OXFORDSHIRE COUNTY COUNCIL'S RESPONSE TO CONSULTATION ON THE FOLLOWING DEVELOPMENT PROPOSAL

Application no: 15/01012/OUT

Proposal: OUTLINE - Development of up to 48,308sqm of employment floorspace (Class B1c, B2, B8 and ancillary B1a uses), the siting of buildings to the south of the site, servicing and circulation areas, vehicular and pedestrian access from Skimmingdish Lane and landscaping.

Location: Land North East Of Skimmingdish Lane Launton Oxfordshire

JOB TITLE Skimmingdish Lane, Bicester		CLIENT Albion Land	
DRAWING TITLE Site Access Proposals (with Taylor Wimpey Access)			
SCALE 1/1000@A3	DRAWN BY BP	DATE May 2015	DRAWING No 15230-08
REVISION A

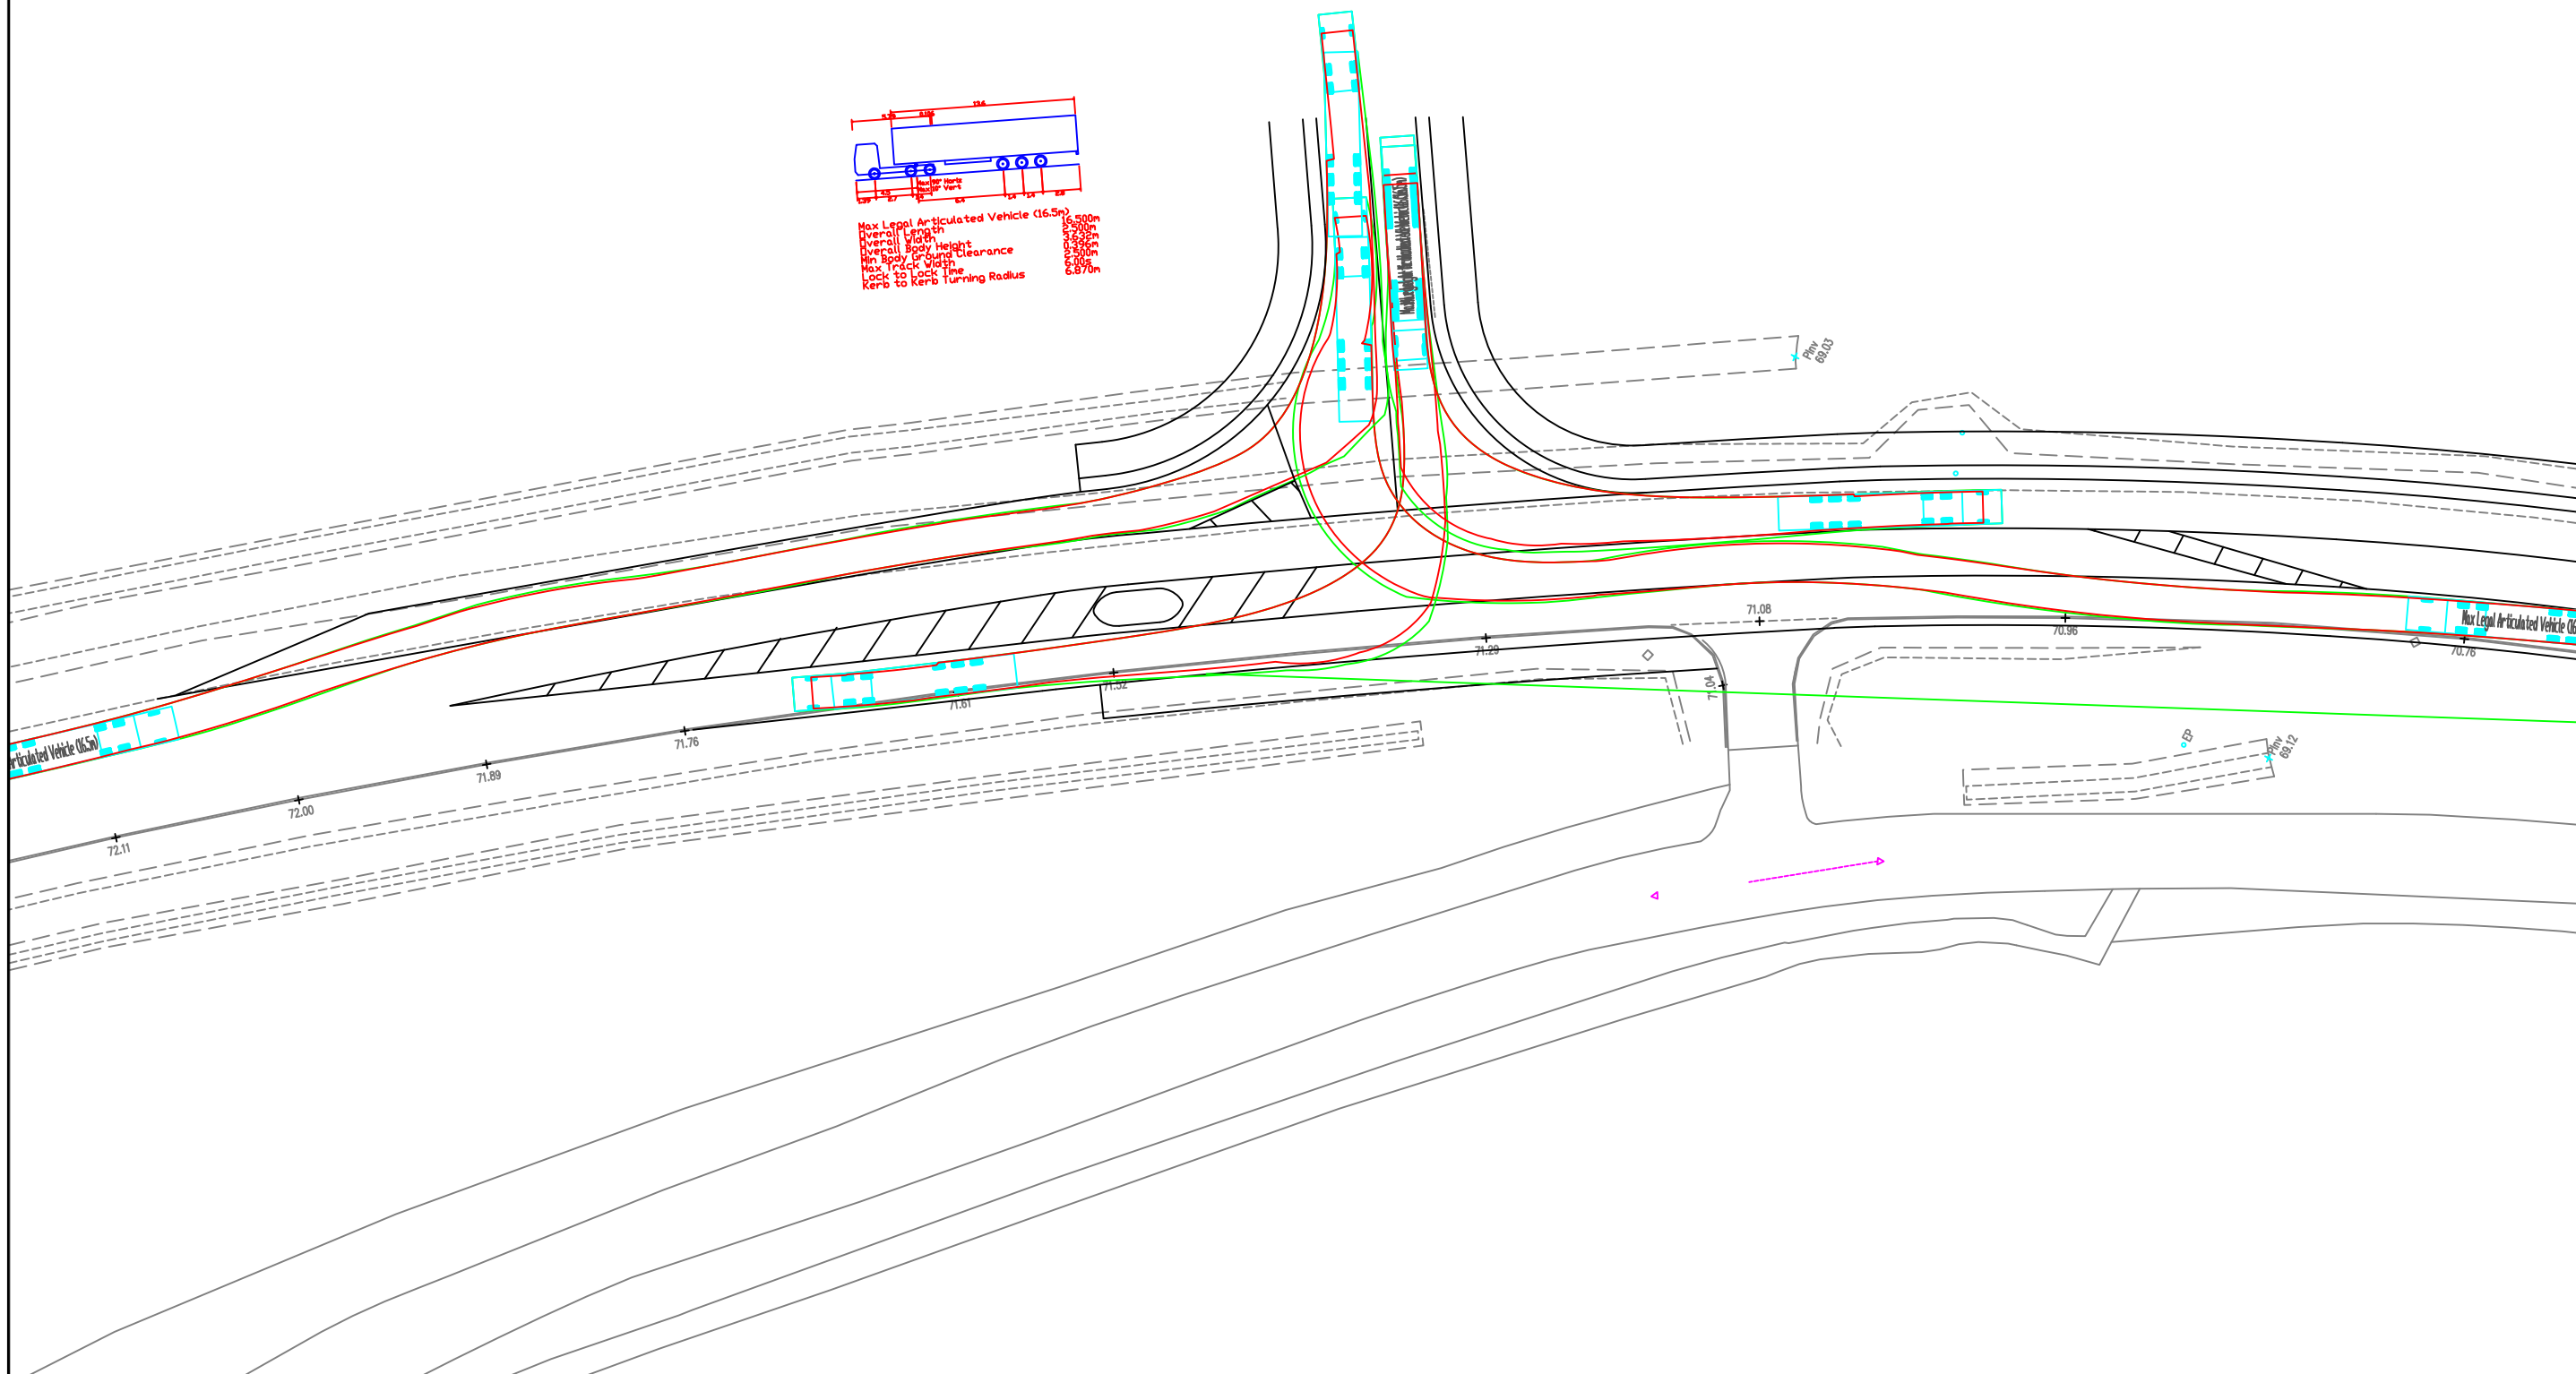
- Priority junction with ghosted right turn, footway/cycleways, signalised crossing, as shown on drawings 15230/07 and /08 in the transport assessment.
- Works required on Skimmingdish Lane to ensure a safe and convenient pedestrian route from the site to the nearest bus stops on Boston Road

The form of junction is considered suitable, but the x distance of the visibility splay is only shown as 2.4m: 4.5m would be more appropriate for the junction which may experience high

volumes of traffic exiting the site at peak times. It should be possible to provide 4.5m and there needs to be an explanation of why 2.4m is provided.

The signalised crossing and new cycleway/footway proposed is extremely important to provide good cycle and pedestrian access. The crossing is considered to be in a suitable position. It should be of the Toucan type, to allow people to cycle across it. (There are two drawings, one showing what would be provided in the case that the site comes forward before the residential development opposite, and one showing what would be provided in the case that it comes forward after that site).

However, a link should be provided from the site to footway/cycleway at the south eastern corner of the site. This will be a desire line and will help shorten walking distance for some users. If not provided, people will break through the boundary in any case and there will be pressure to provide a path.
